**Your Ref: 2026/0640
Our Ref: B/02707**

22nd September 2026

Land south of Cemetery Road, Jump, Barnsley S73 0QN - (BARNS) Residential development of 270 new dwellings, together with access, public open space, landscaping, drainage infrastructure and associated works

LANDSCAPE MASTERPLAN

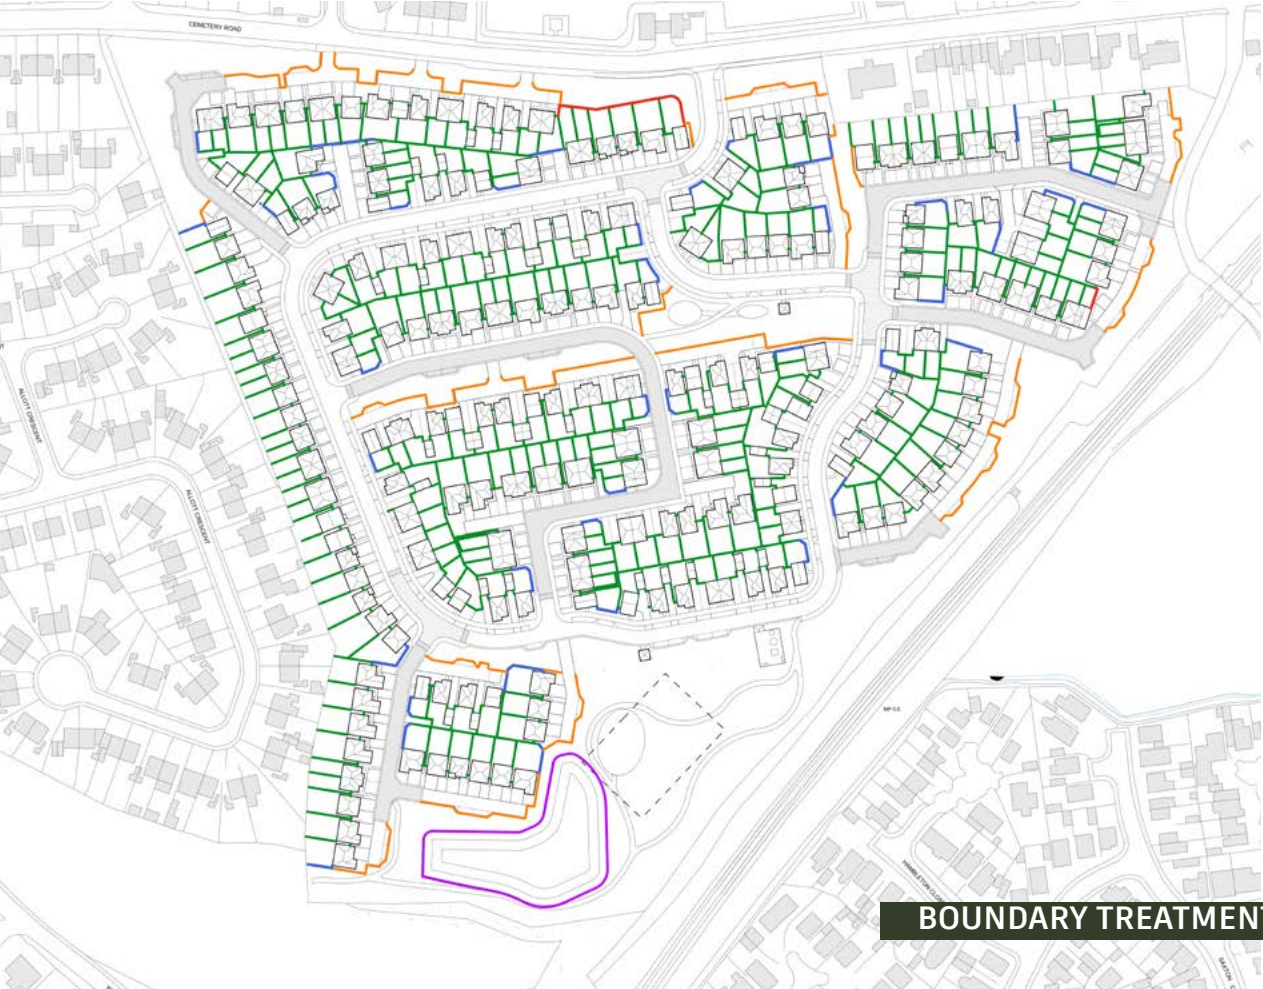
1.) The layout and landscaping details submitted on drawing 'LANDSCAPE MASTERPLAN' 404.064778.00001 (revision 00) dated May 2026 that has been prepared by SLR is not acceptable. The following point(s) should be addressed:

- a.) the submitted drawing appears to show new tree planting proposed within the stand-off distance of the public sewer network recorded to cross the site.
- b.) the submitted drawing should show the site-surveyed position of the public sewer crossing the site
- c.) the submitted drawing should show the required building and tree planting stand-off from public sewer -- or an agreed alternative scheme

On the Statutory Sewer Map, there is a 300mm diameter public surface water sewer recorded to cross the site. It is essential that the presence of this infrastructure is taken into account in the design of the scheme.

In this instance, a stand-off distance of 3 (three) metres is required at each side of the sewer centre-line and it may not be acceptable to raise or lower ground levels over the sewer, nor to restrict access to the manholes on the sewer.

There should be no new tree planting within 5 metres of the public sewer network.
